KITTITAS COUNTY

DEPARTMENT OF PUBLIC WORKS

MEMORANDUM

TO: All Staff
FROM: Public Works Plan Review Team
DATE: November 13, 2023
SUBJECT: SP-23-00009 Sparks

BOWERS ROAD SHORT PLAT
 PART OF SECTION 26, T. 18 N., R. 18 E., W.M.
 KITTITAS COUNTY, WASHINGTON

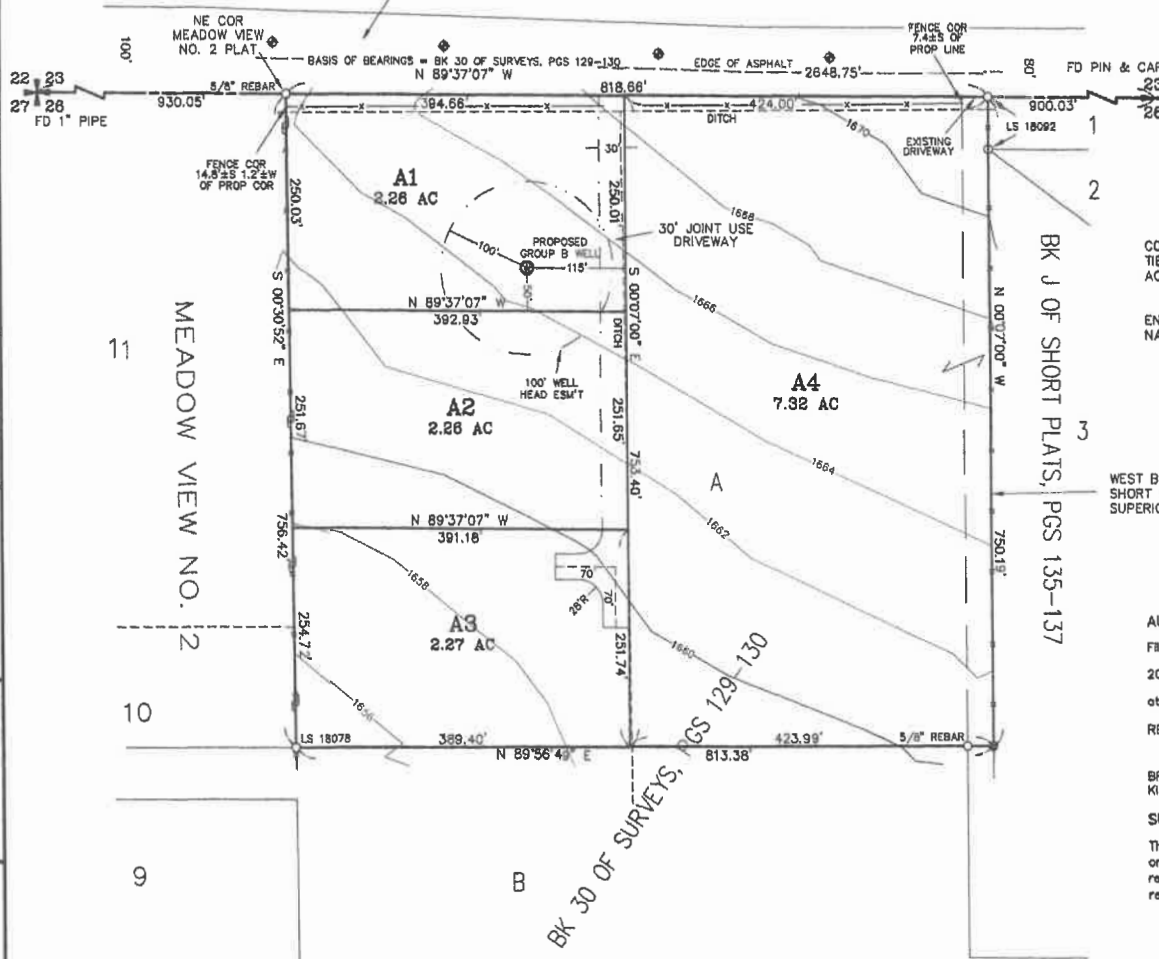
SURVEY	<p>The following survey comments will need to be addressed prior to final approval:</p> <ol style="list-style-type: none"> 1. Interior property corners will need to be set and shown on the final Short Plat. 2. Please include language showing the 30' Joint Use driveway <u>Easement</u> as either existing, herein dedicated, or created by separate document. 3. Please include suitable information for the accurate retracement of the 30' wide Joint Use Driveway Easement... particularly in the turnaround area. <p>OF NOTE (no changes required)</p> <ol style="list-style-type: none"> 4. The "Found Encased Monuments" shown falling near the centerline of Bowers Road, would typically need to show bearing and distance ties in order to retrace their positions. It is presumed that these monuments are shown only as convenience, and are not part of any survey control network requiring retracement. 5. Lot closures were not provided as part of the application. Given the simplistic nature of the lot layout, closure reports are not required. (JT)
